DEVELOPMENT HEARING OFFICER

DRB Project Number: 2022-006746
1748, 1752, 1756 Cliffside

SUBJECT: Preliminary/Final Plat

Project Name: Lots A-26-A & A-26-B, Block 4, Vista Magnifica Subdivision

**PLAT OF
LOTS A-26 & A-24-A, BLOCK 4
VISTA MAGNIFICA SUBDIVISION**

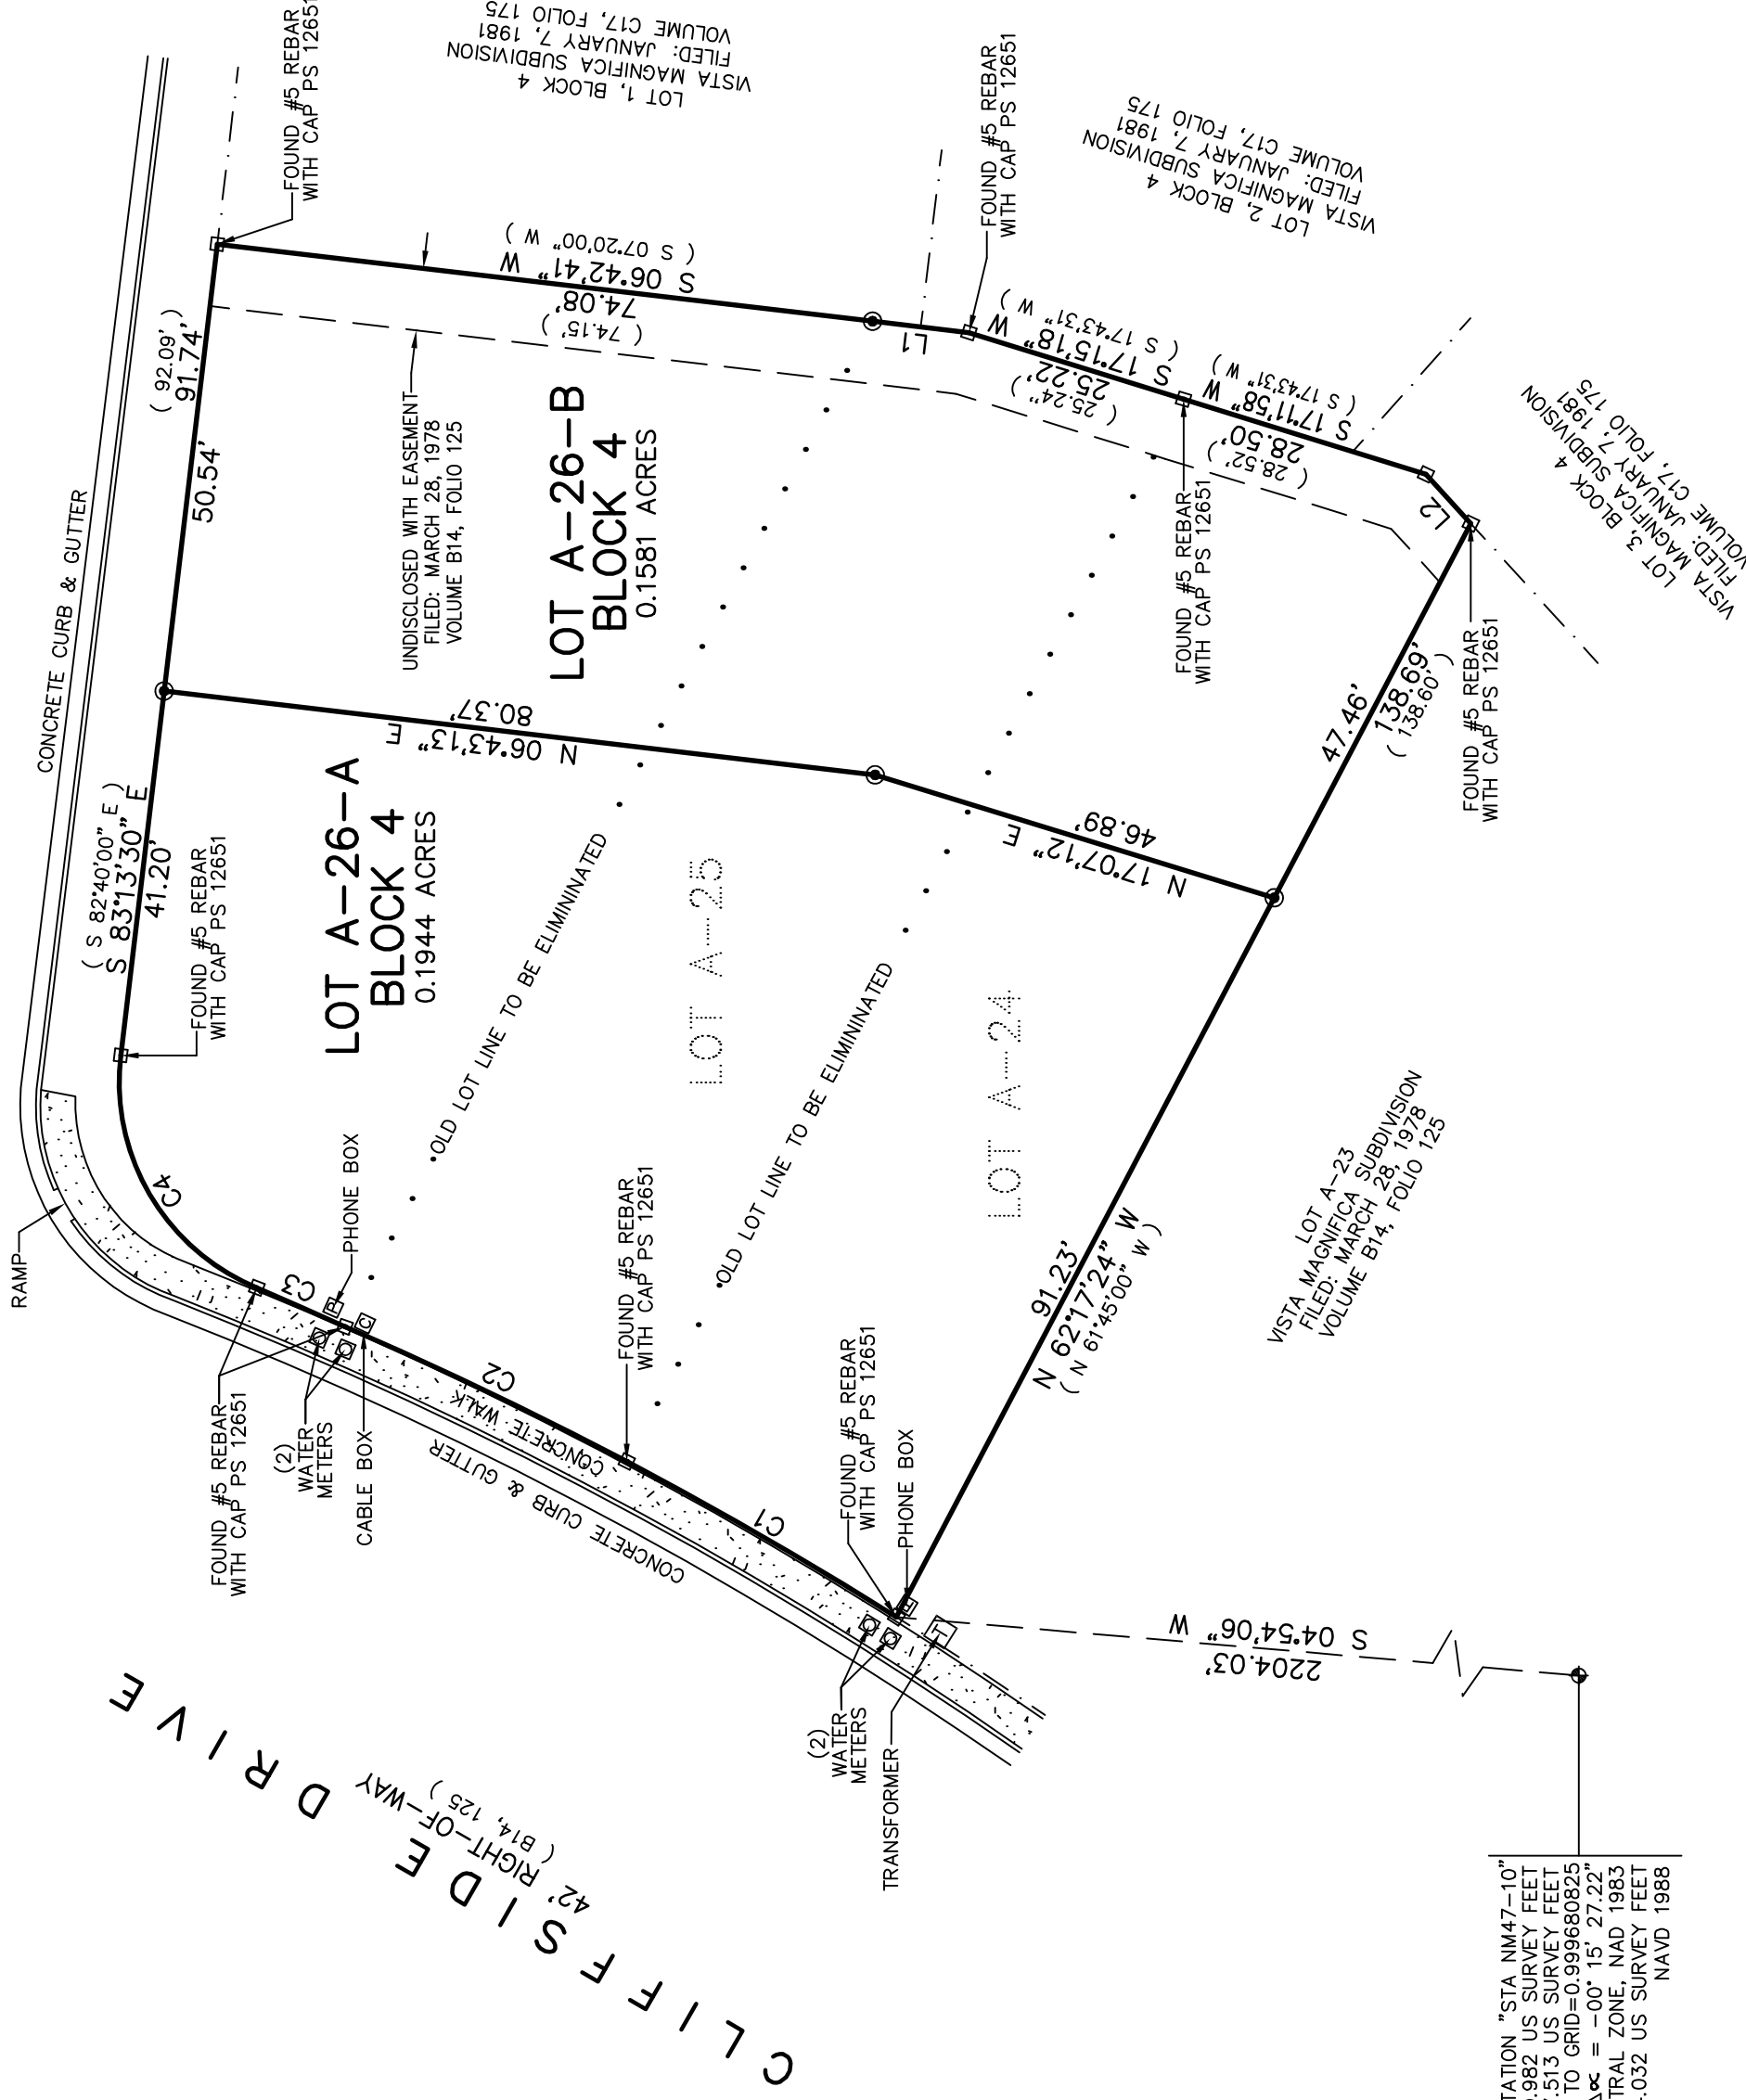
3. Front Lot Line must be located along Cascade Place, and therefore the Front Façade of Home should be facing Cascade Pl, as well (proposed drawing shows what appears to be front façade along Cliffside Drive).
4. Code Enforcement has no further comments, and no objections if the properties face and are addressed off of Cascade Place.

LEGAL DESCRIPTION:
 LOTS A-26-A & A-26-B BLOCK, 4

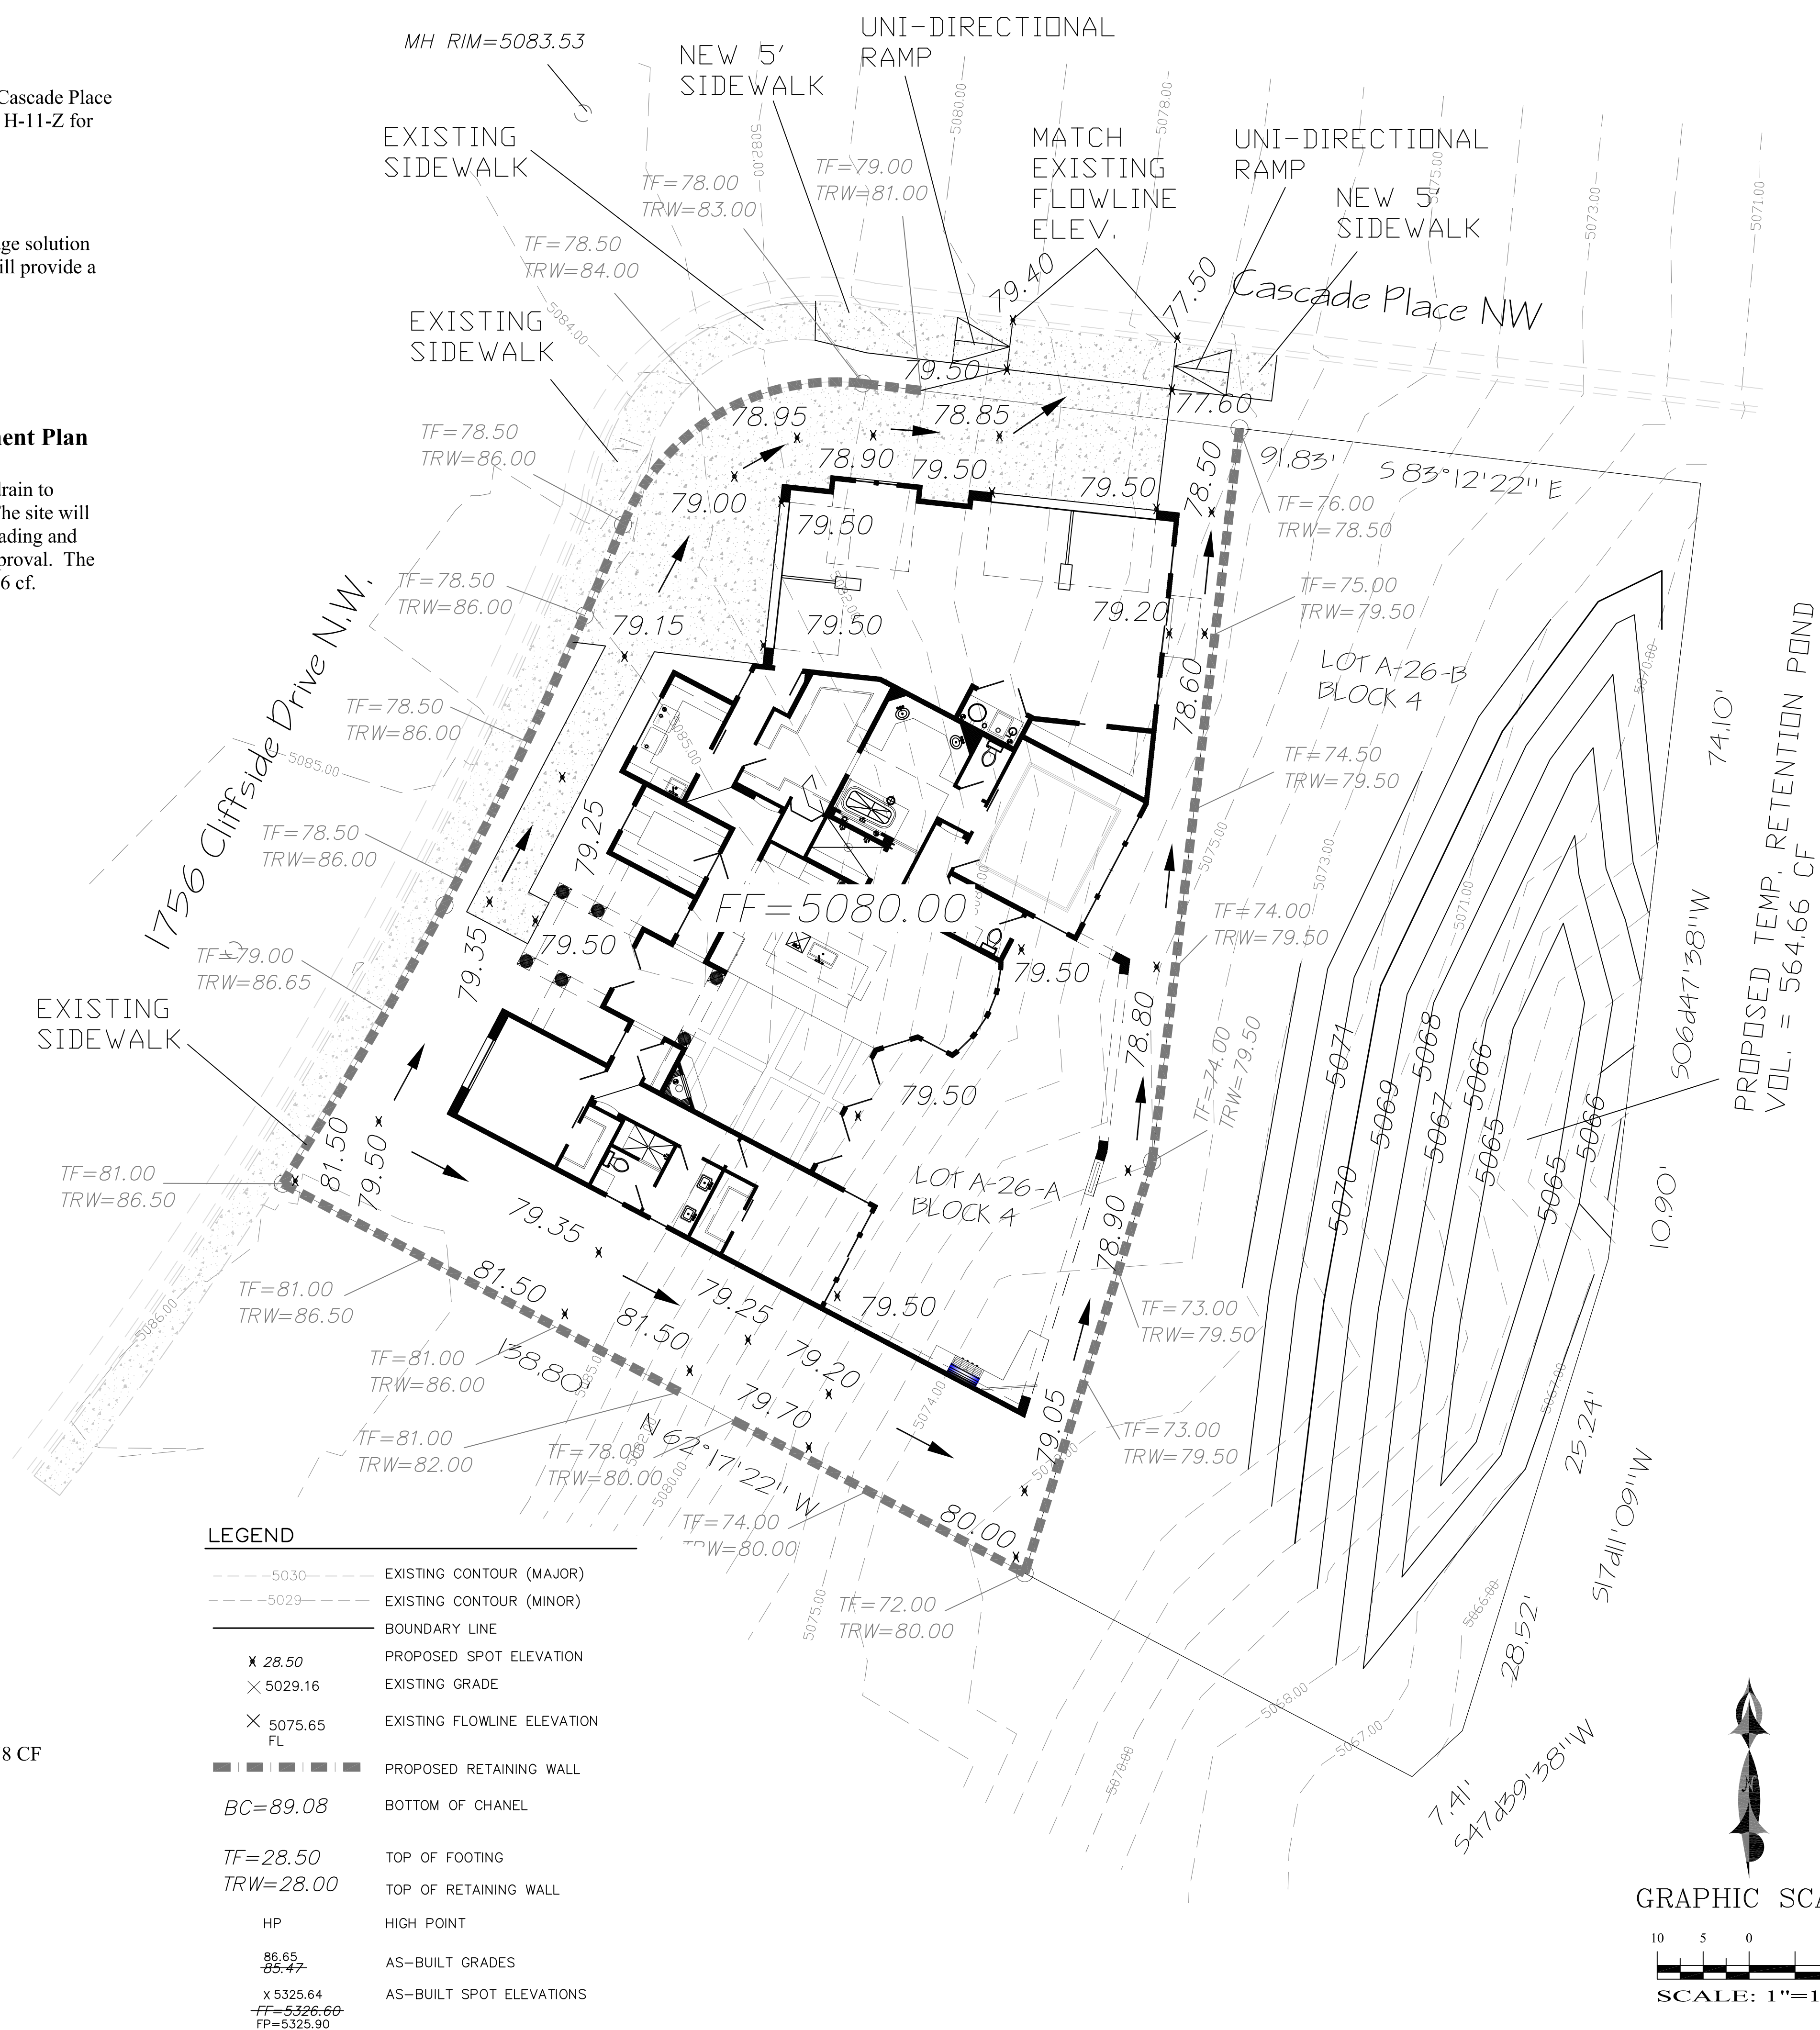
1. Transportation is satisfied with the justification letter for the ROW.
2. 5' sidewalks with a 4-6' landscape buffer is required along both roadways. Your plan shows a proposed 5' sidewalk along Cascade but your infrastructure list shows it as 4'. The infrastructure list should be updated to show 5' sidewalk.

- Confirm if the sidewalk and landscape buffer along Cliffside Drive NW and Cascade Place NW are/would be in ROW or within an easement.
- The Grading Plan included with the Minor Preliminary/Final Plat application submittal depicts a 5-foot wide sidewalk along Cascade Place NW. However, the Infrastructure List depicts a 4-foot wide sidewalk. The Infrastructure List must be updated to reflect the 5-foot sidewalk width depicted on the Grading Plan (which meets the DPM requirements for sidewalk width).
